From: Simon Davis
Sent: 20 April 2021 10:49
To: Megan Green [REDACTED]
Cc: Chris Brake [REDACTED]
Subject: RE: AL/20/21/PL - Wings Nursery, Lidsey Road, Woodgate

From: Simon Davis <Simon.Davis@arun.gov.uk>
Sent: 14 April 2021 17:49
To: Megan Green [REDACTED]
Cc: Chris Brake [REDACTED]
Subject: AL/20/21/PL - Wings Nursery, Lidsey Road, Woodgate

I write as promised with our comments on the application.

Urban Form Diagram

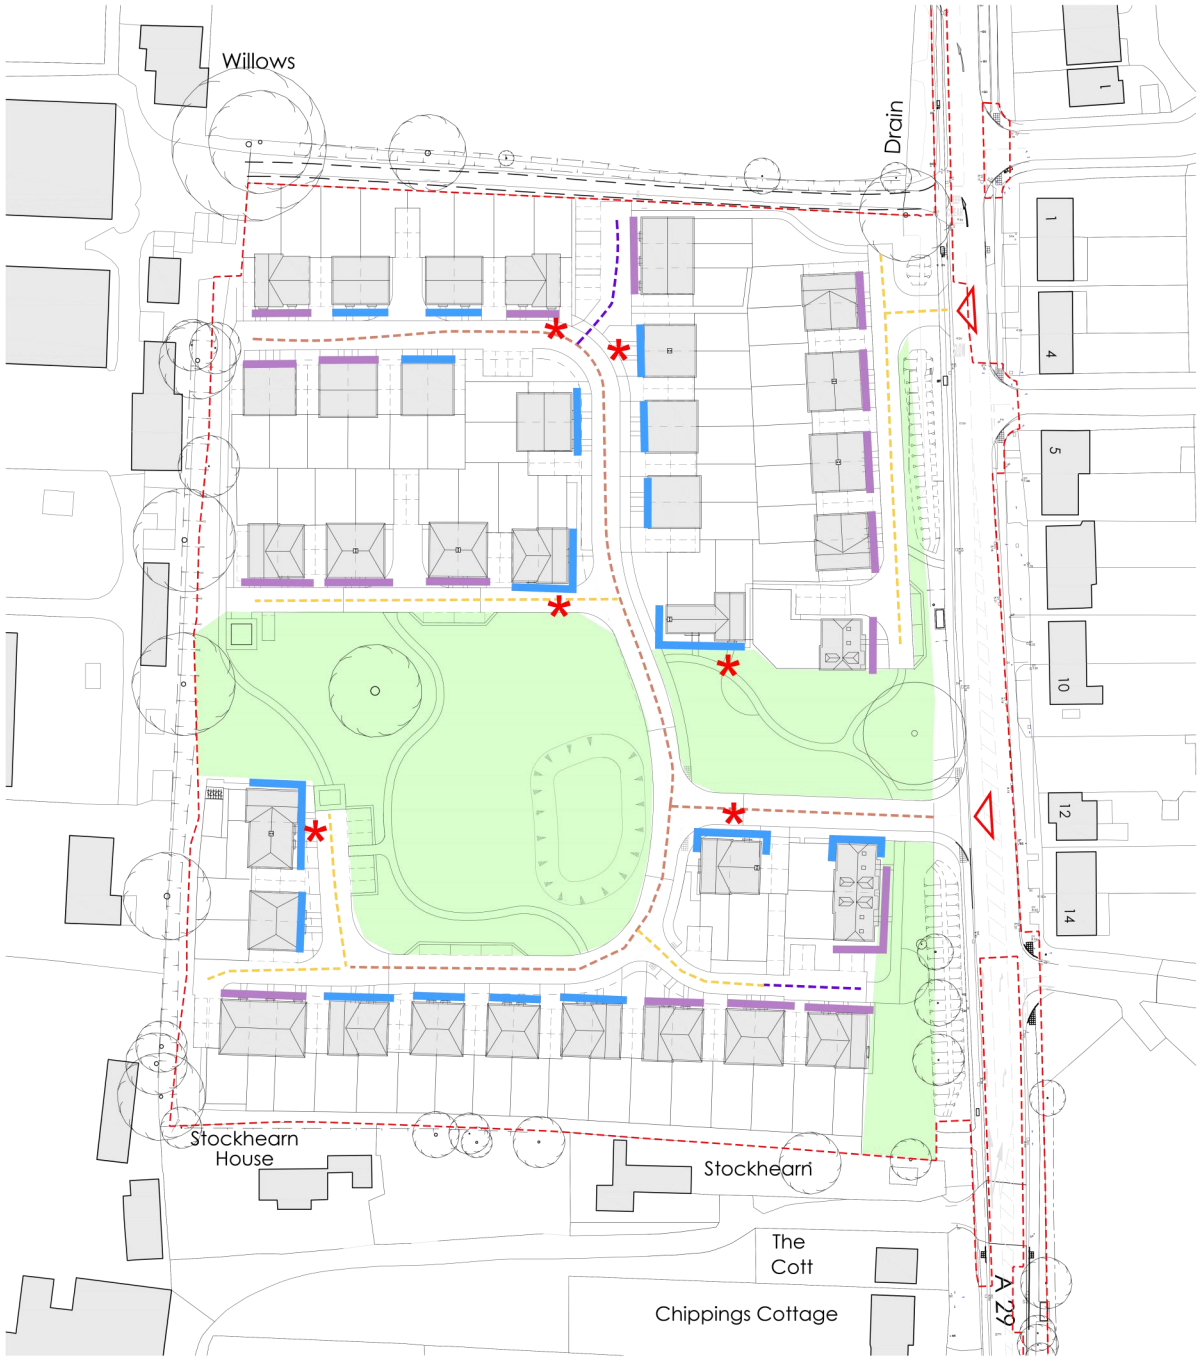
- I have the following issues with the layout:
 - The street trees in locations at/near plots 10, 35, 44-48, 51-53 don't appear to have room to grow being sandwiched by hard standing and prone to future pressure for removal due to their canopies being over parking spaces.

- The fronts of plots 42/43 look straight into plot 44's private garden
 - Plot 47 has its parking to the side but also 46's parking spaces to its front. This is not ideal from an amenity perspective.

- Plot 61 will likely park on the road not in the allocated spaces at the rear
 - Plot 62's spaces are accessed from a different road to its front
 - Plot 28 part faces a timber substation enclosure. Can this be moved backwards a little to enable a hedge/trees to be planted to its front with then access from the side.

- There are some shortfalls versus the Design Guide interface distances within the layout:
 - plot 37 rear to 38's side is 12m (2m shortfall)
 - some rear-to-rear distances are in the range of 20-21m (so up to 1m shortfall)

- plot 19 front to 22's side is 10m (4m shortfall)
 - plots 40/41 front to 44's side is 8.4m (5.6m shortfall)
 - plots 36/37 front to 57/58's front is 12.3 (3.7m shortfall)

- Make plots 44-47 all front south onto the road (so have the same building line as 48-51). Plots 44-51 should then all have on-plot parking.
- Redesign the arrangement of plots 61-63 so that all three front onto a road and have on-plot parking.
- The internal site interface distances need to be resolved so as to ensure that they are Design Guide compliant (or certainly much closer to the stated standards)
- I am informed that it is not necessary for plots 24-27 to have individual gardens so the subdivided area can be made onto a communal space.
- Relocate the substation or better screen it so that no house directly looks out onto it.
- Increase the space for street trees.
